DEVIATION REQUEST AND DECISION FORM

SM Rocha LLC
Response to Comments
August 2026

Project Name : The Markets at Bent Grass
Schedule No.(s) : TBD
Legal Description : TBD

**RE: The Markets at Bent Grass Development
Conceptual Access Spacing Deviation Request**

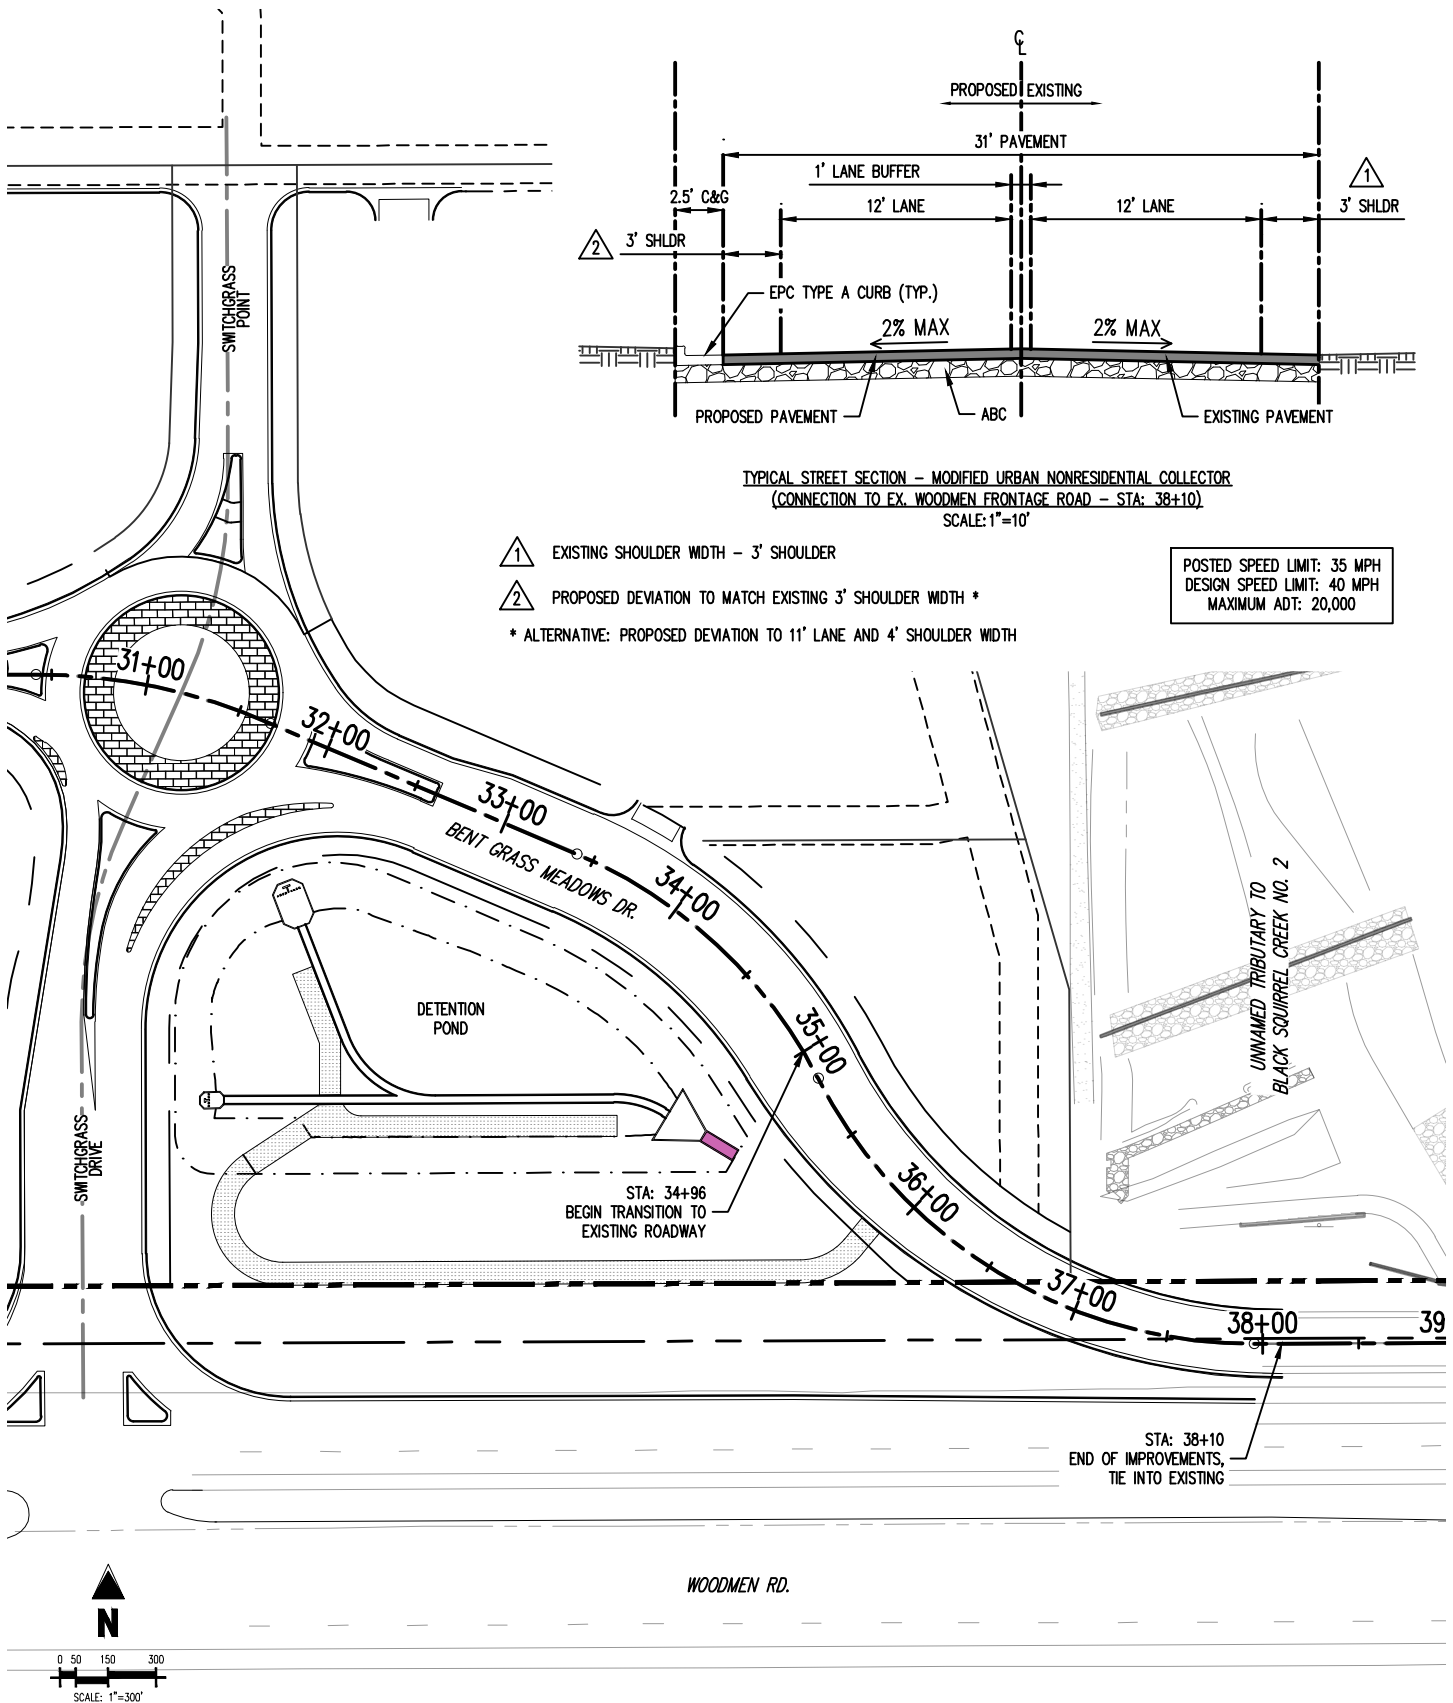
provide exhibit showing locations

(maybe also use striped 11' lanes on rural x-section of frontage road?)

Provide an exhibit showing approximate locations of 25 MPH signs (ahead of curves seems appropriate)

SMR: Exhibit included in Attachment B of Deviation Request letter.

SMR: Exhibit included in Attachment B of Deviation Request letter.

SMR: Additional discussion added. Proposed MPH sign locations described on provided exhibit.
